From: [REDACTED]
Sent: 29 July 2018 16:47
To: Planning
Subject: Additional Comments re A/36/18/OUT

Further to my earlier correspondence with you relating to the above application, consequent to the applicant's revised Transport Assessment, I make additional observations as below. (I apologise for being unable to contain these observations to the required character limit for online submissions).

Figure 5.4: Proposed main vehicular access point off Arundel Road.

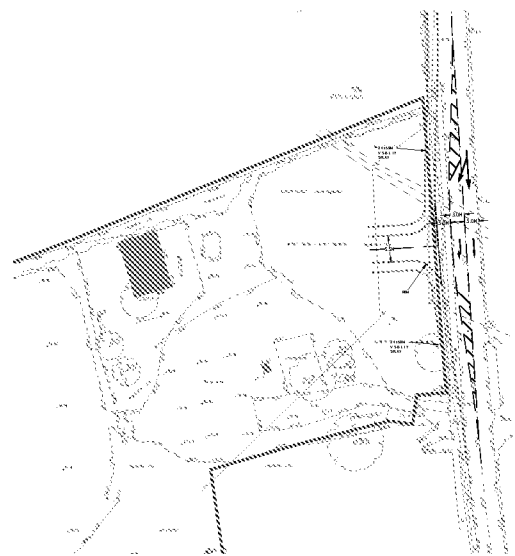
The Safety Auditors' comments relating to the encroachment of refuse vehicles into adjoining lanes at the proposed primary access, are dismissed by the engineers who imply that the encroachment would be "minimal." This is not the view of the auditors, who are clearly and understandably, concerned as to the extent of encroachment displayed within the submitted Swept Path Analysis and show effectively complete occupation of opposing traffic lanes.
